M42 Junction 6 Development Consent Order

8.16 Statement of Common Ground with National Exhibition Centre Limited

October 2019

Drawing Title
FIGURE 3.6 WESTERN POWER PROTECTION AND DIVERSION WORKS SHEET 1 OF 2

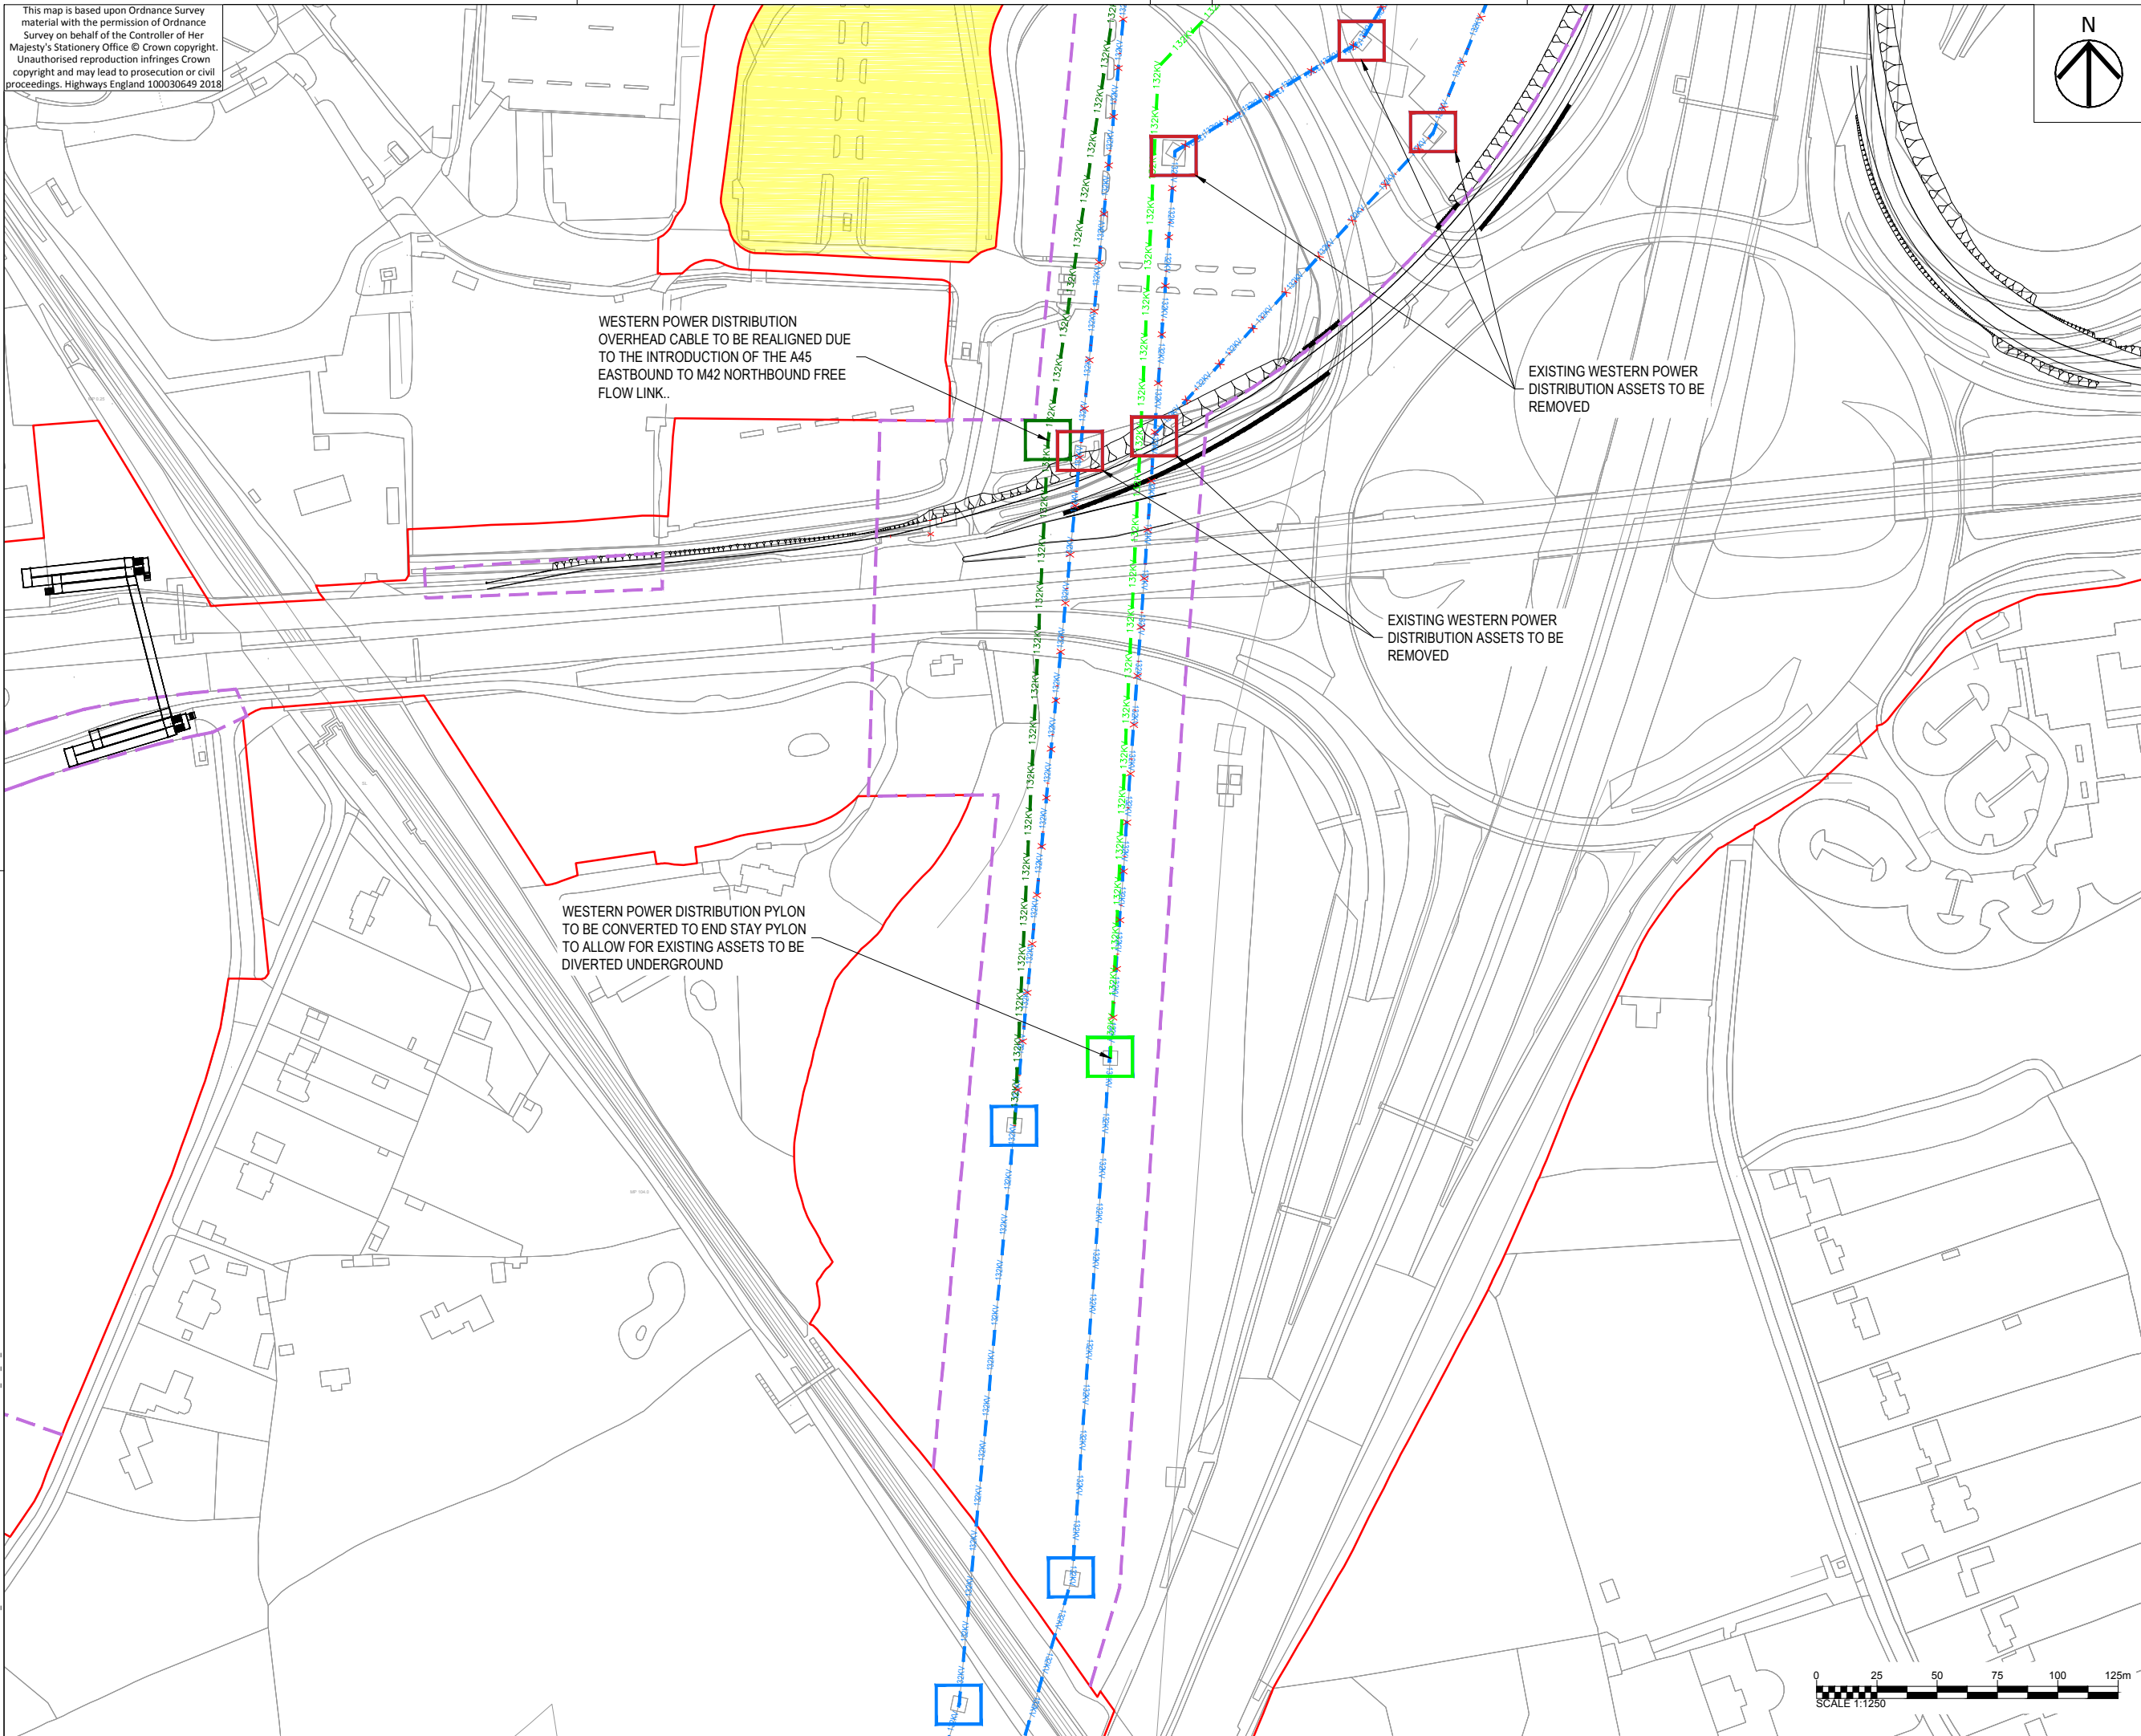
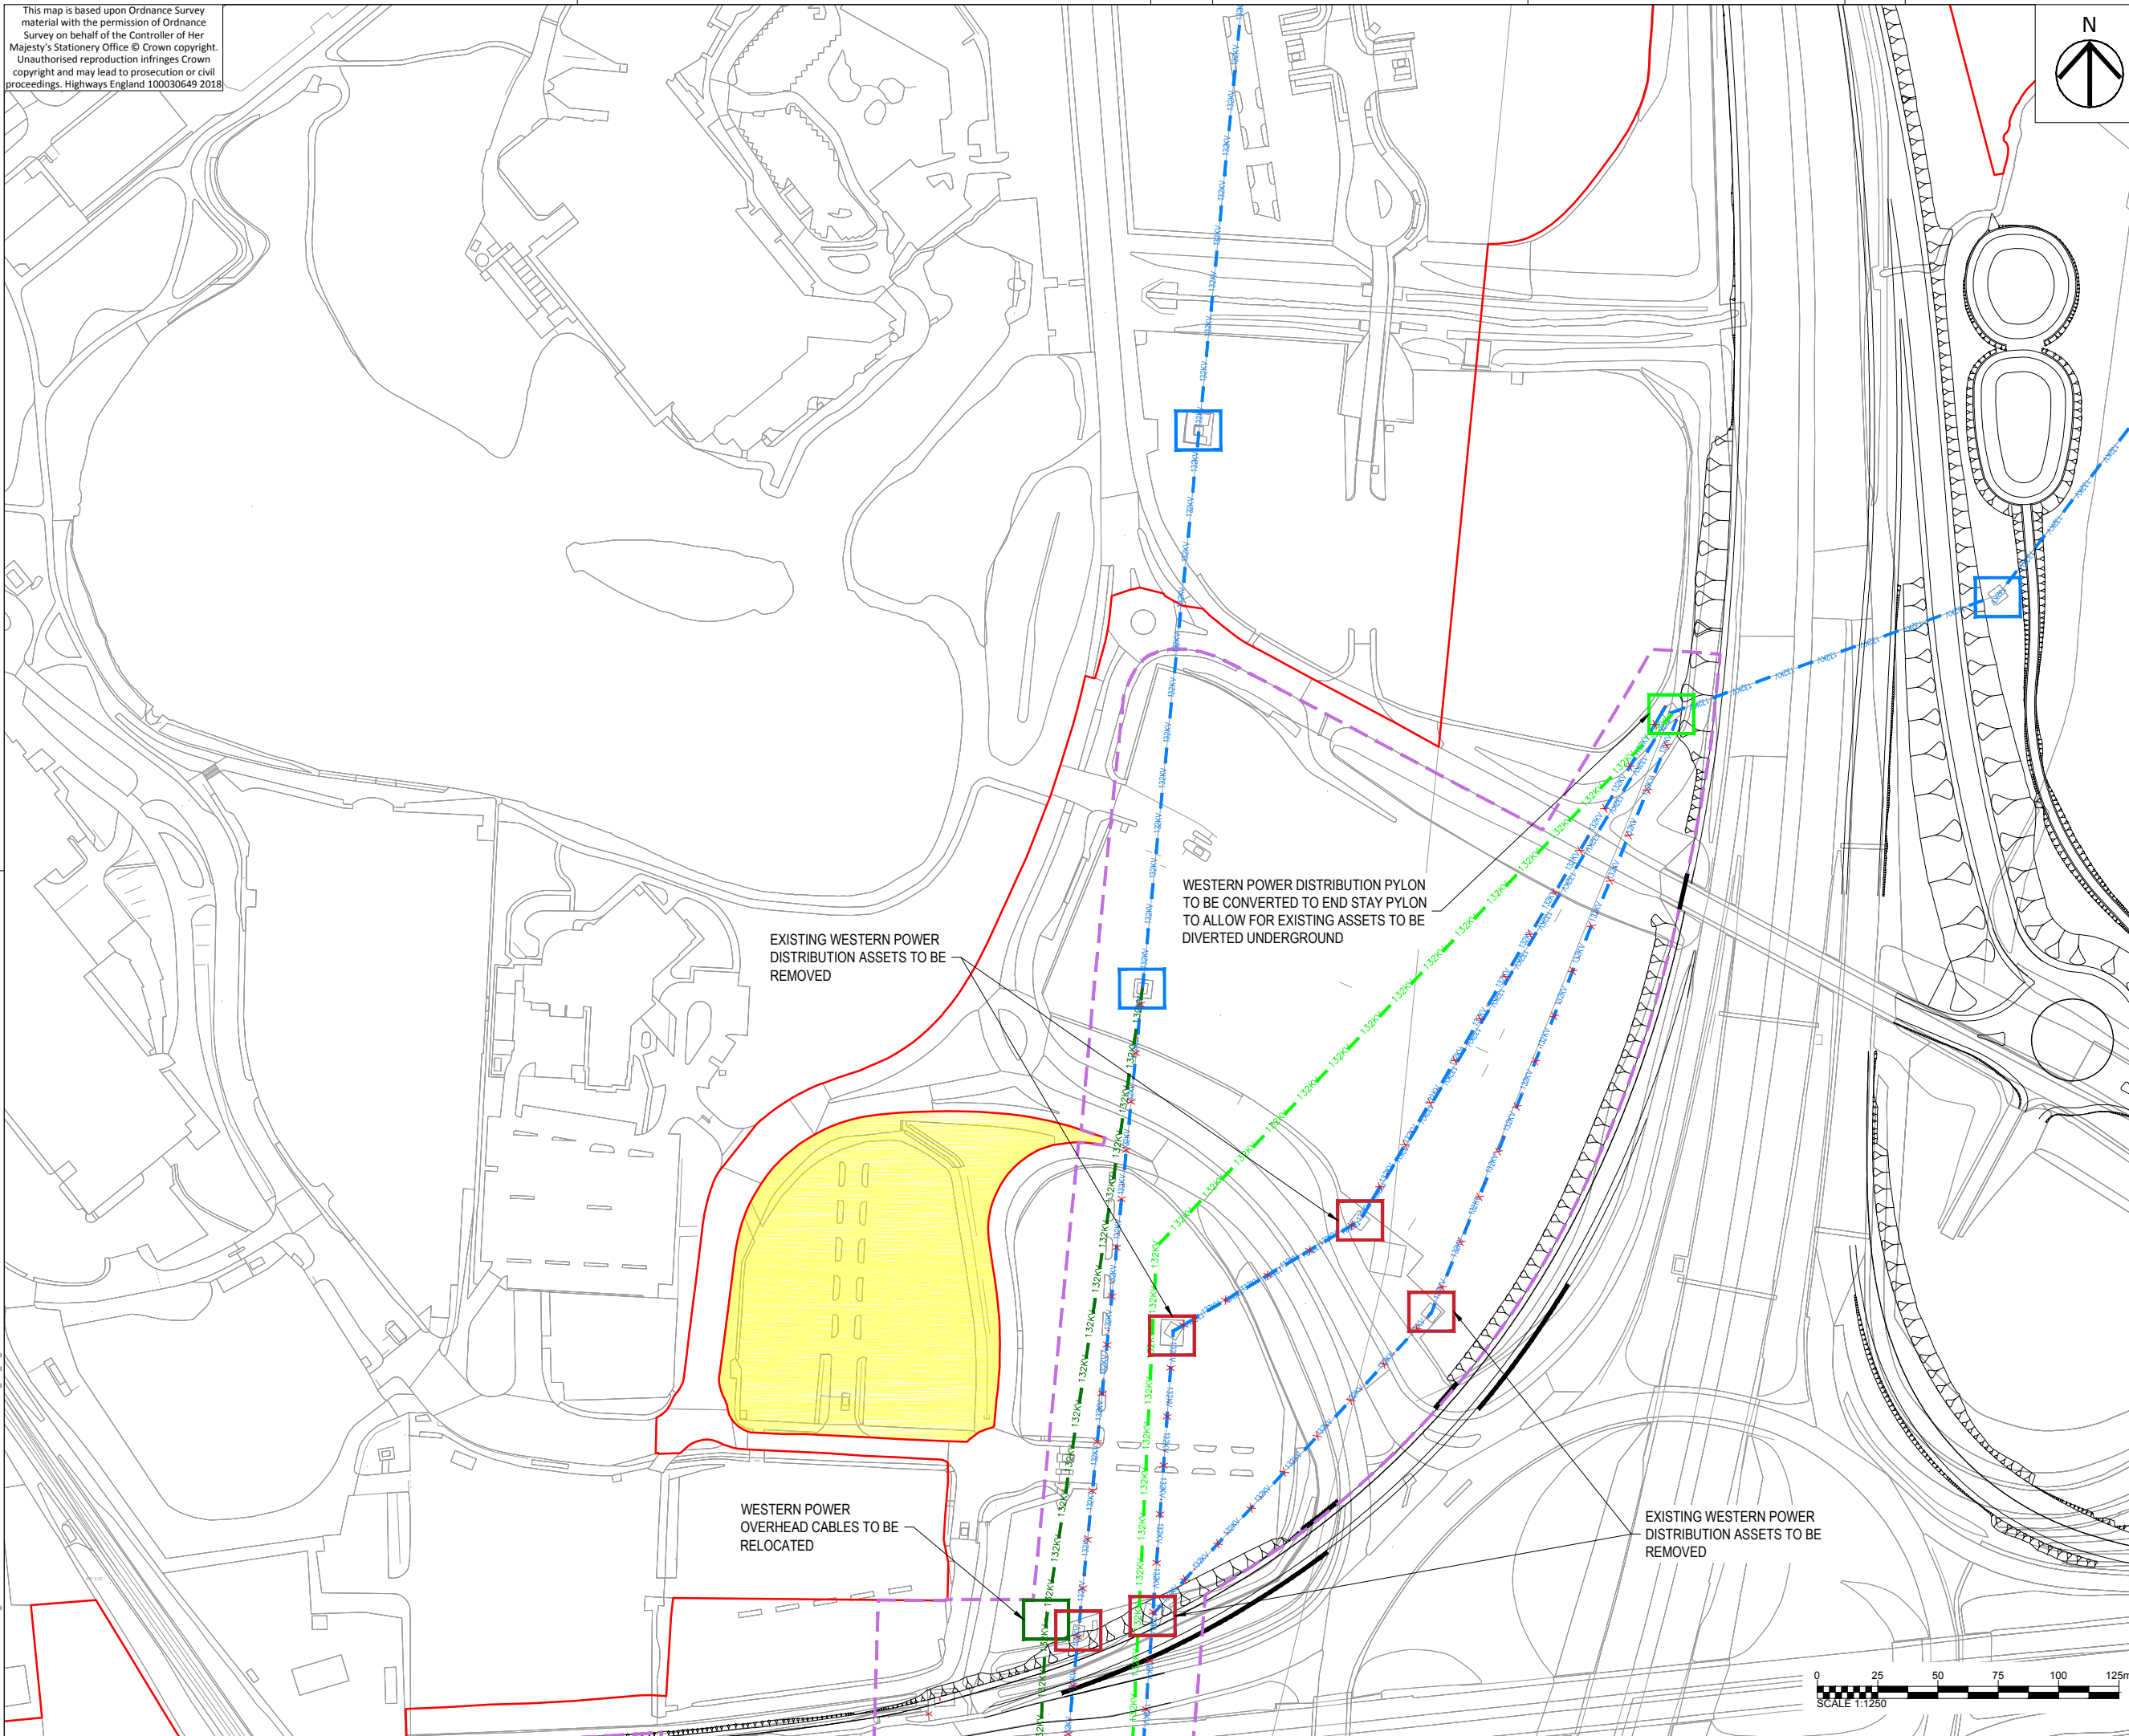
| Sub-topic | NEC Comment | Highways England Response/Actions | Status/Agreement |
|-----------|--|--|------------------|
| | <p>South car parks are critical for certain events and without which could risk the loss of the event.</p> <p>➤ provision of a dedicated replacement access road to the rear of car park S5 and S7 (the detail of which to be agreed between the parties);</p> <p>The NEC notes that until the WPD report is completed and reviewed Highways England are not in a position to comment regarding the minimisation of land take. We do however reiterate the NEC's position that significant loss of land on either a temporary or permanent basis will have a substantial business impact through the incurrence of additional costs, for example, potentially preventing the NEC from taking business, or resulting in lost events and consequent revenue. Of concern is the lack of clarity on phasing, scale and</p> | <p>closely with the NEC and use all reasonable endeavours to ensure that these car parks are made available to the NEC for this event. The use of Millennium Way for a site compound to assist with the handing back of car park spaces will be explored with the NEC.</p> <p>Highways England will also review the works undertaken during the period of the HOYS to ensure they are not of a nature that will upset the horses stabled at the site during this time.</p> <p>Highways England understand that there will be a requirement to suspend works during the Commonwealth Games in 2022. However, there may be remote works elsewhere across the Scheme that can continue during this period, which do not impact the operation of NEC or the Commonwealth Games.</p> <p>Highways England will liaise with the Commonwealth Games organisers to ensure they comply with the highway works embargo in place during this time.</p> <p>Highways England can confirm that they are looking to revise the environmental</p> | |

| Sub-topic | NEC Comment | Highways England Response/Actions | Status/Agreement |
|-----------|--|--|------------------|
| | <p>timings around temporary possession. The NEC requests that greater certainty is given in this regard in order to better ascertain any potential impact on events taking place.</p> <p>The NEC emphasises its request that the redline boundary only includes land which is necessary (on both a temporary and permanent acquisition basis) for the construction of the Scheme and that HE confirms its indicative timings for taking possession along with phasing.</p> | <p>mitigation strategy in order to retain the access road to the rear of car parks S5 and S7 and shall provide an update to the NEC on this matter in due course.</p> | |
